RE: NSW EPA AND DPIE REQUEST FOR ADDITIONAL INFORMATION – PROPOSED RESOURCE RECOVERY FACILITY (RRF), 16 TORRENS ROAD, GUNNEDAH

Martens have reviewed the request for additional information (RFI) provided by NSW Department of Planning, Industry and Environment (NSW DPIE), NSW Environment Protection Agency (NSW EPA) and Gunnedah Shire Council (GSC), and provide the following response and additional detail:

DRAWING TITLE				
SWEEP PATH ANALYSIS PLAN - B DOUBLE				
PROJECT NO.	PLANSET NO.	RELEASE NO.	DRAWING NO.	REVISION
P1907434	PS01	R16	PS01-GZ10	L

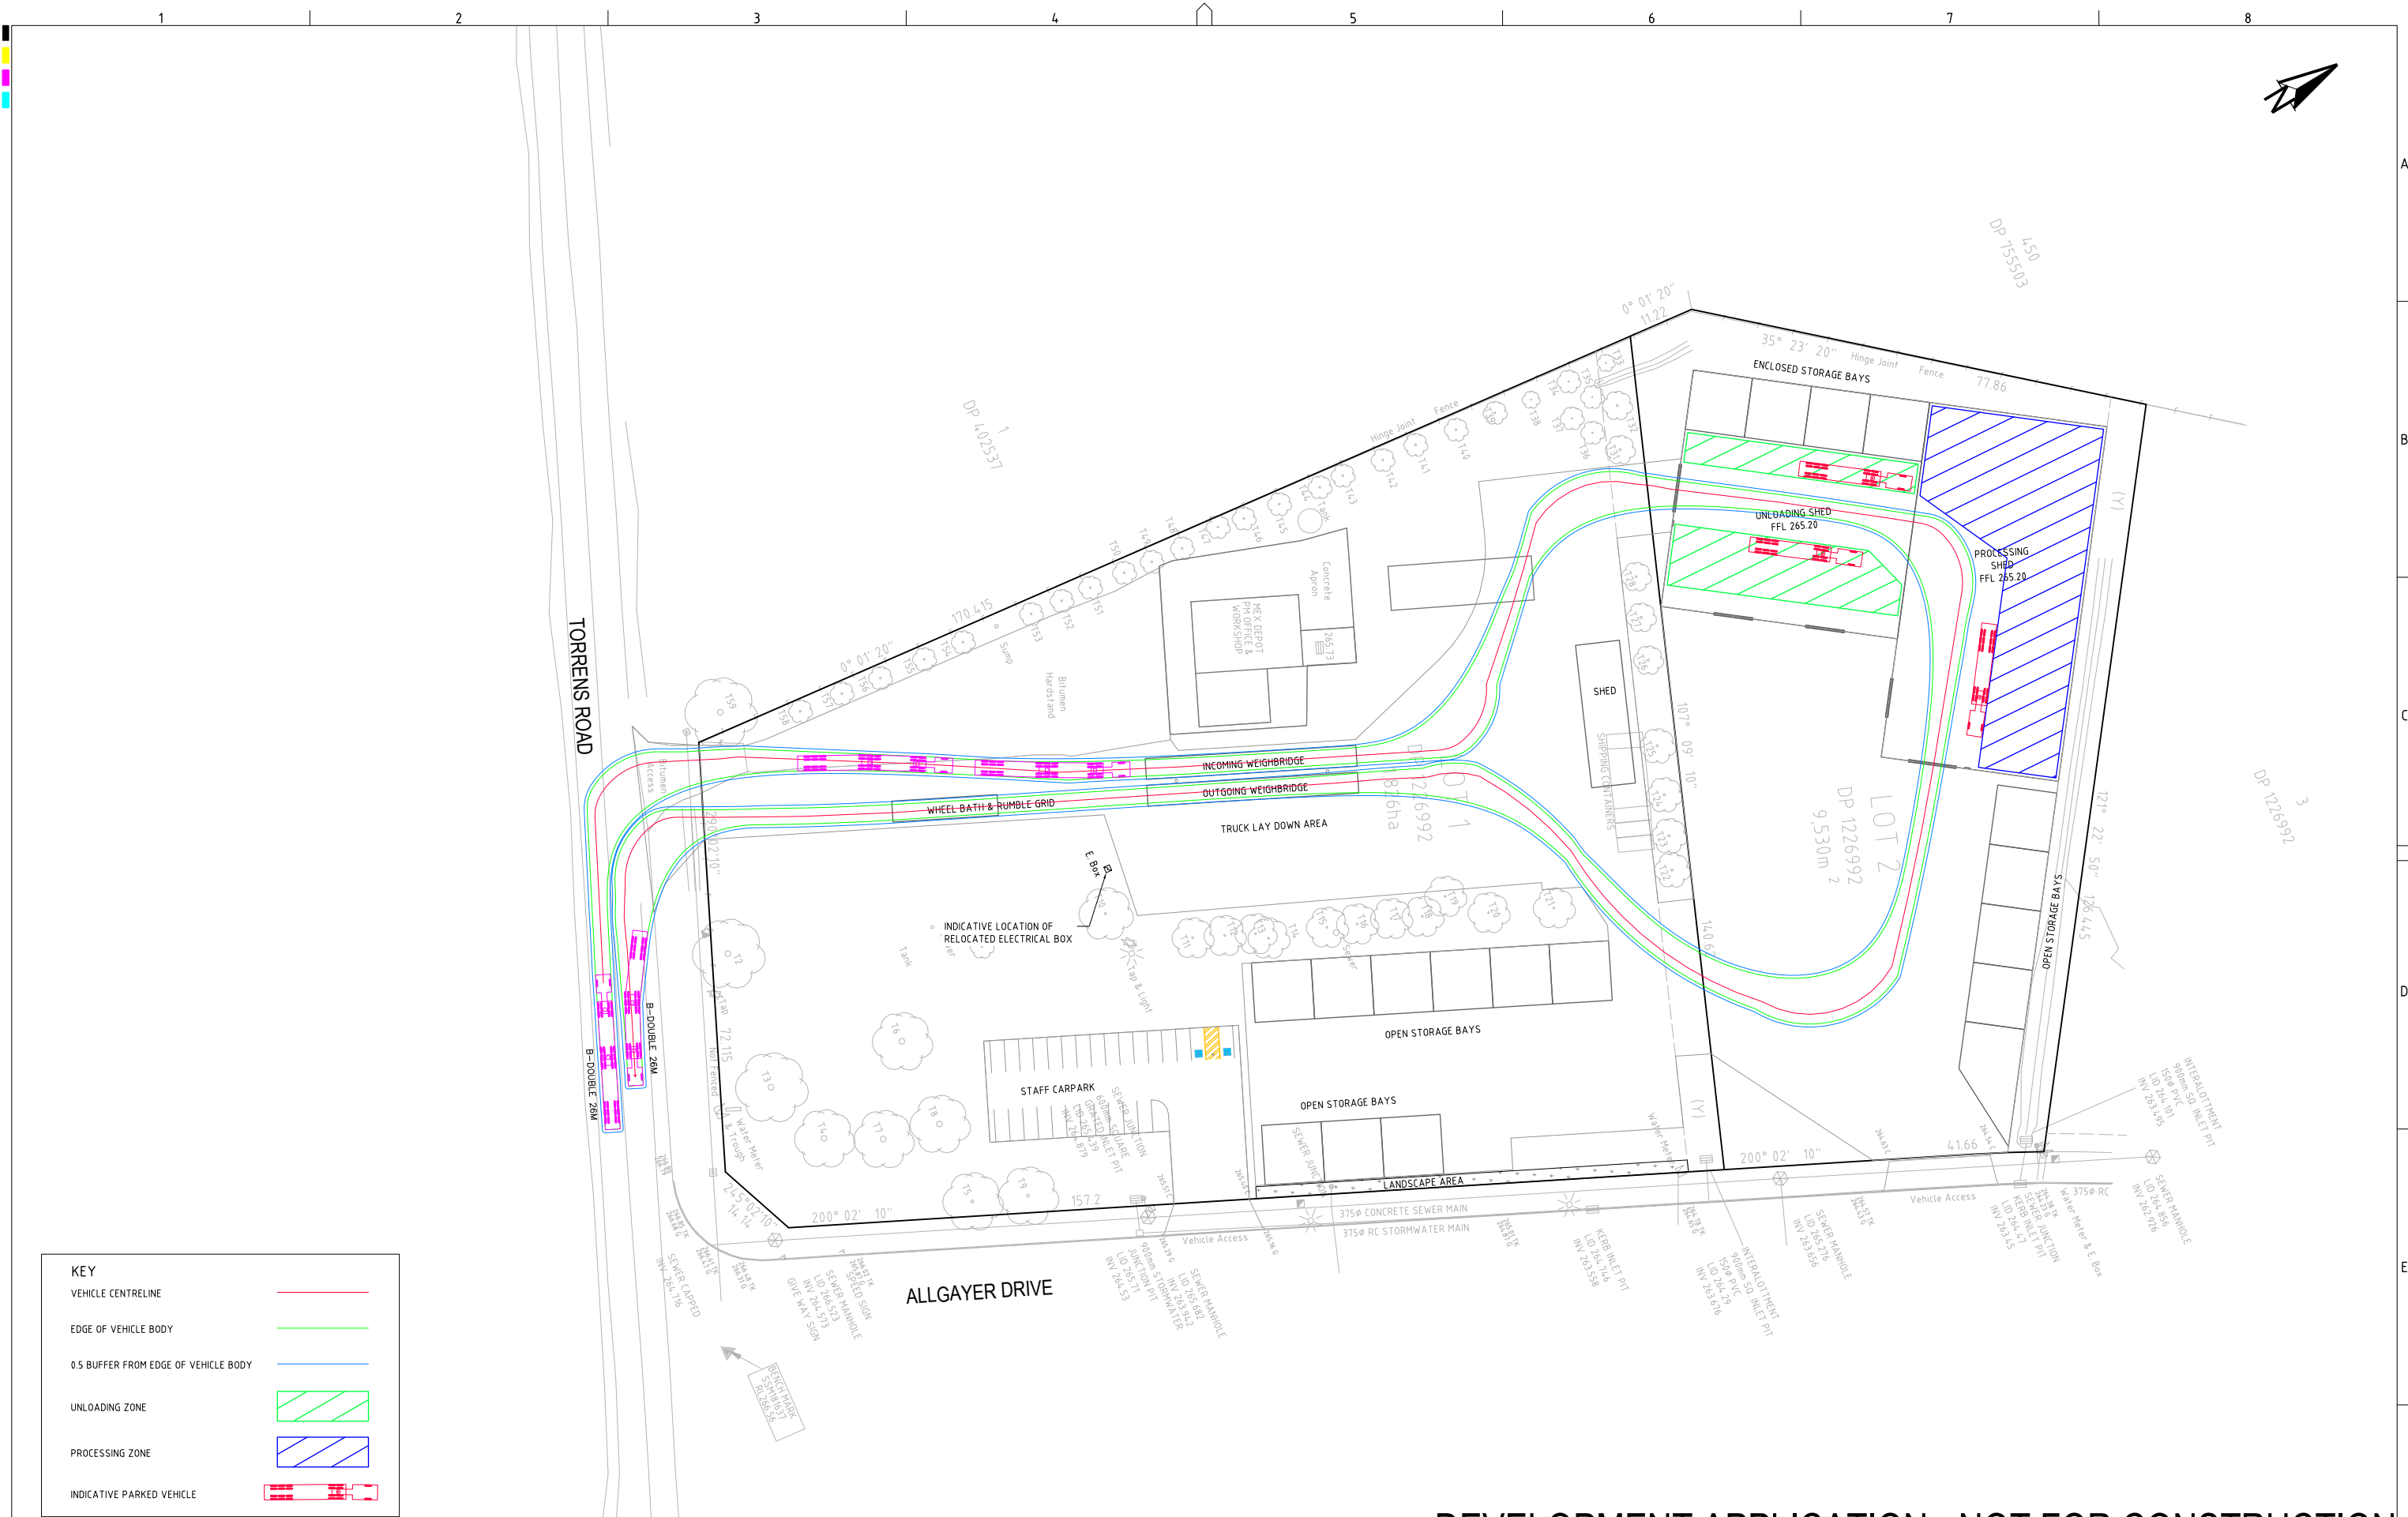
Confirm the largest vehicle expected to enter the site and provide swept paths for this vehicle. Please provide swept path diagrams showing vehicles exiting the site onto Torrens Road.

Internal driveways are to be sealed and extended to ensure that all vehicles can manoeuvre within the site, especially B-Doubles. The current swept path analysis plan for B double vehicles by Martens & Associates Pty Ltd, indicates manoeuvring is unable to be achieved within the indicated internal driveway.

Swept path analysis has been undertaken for the following design vehicles:

All swept paths indicate that adequate manoeuvring is achieved within the site and demonstrate that all vehicles can enter and exit the site in a forward direction.

The entry driveway allows for a maximum number of the following queued large vehicles before the incoming weighbridge, while allowing a B triple to turn out of the site:

- 3 AVs.
- 2 B doubles.
- 2 B triples.

The B triple will need to wait for an incoming vehicle to enter the site before it can exit. All other vehicles can exit the site simultaneously with a vehicle turning into the site.
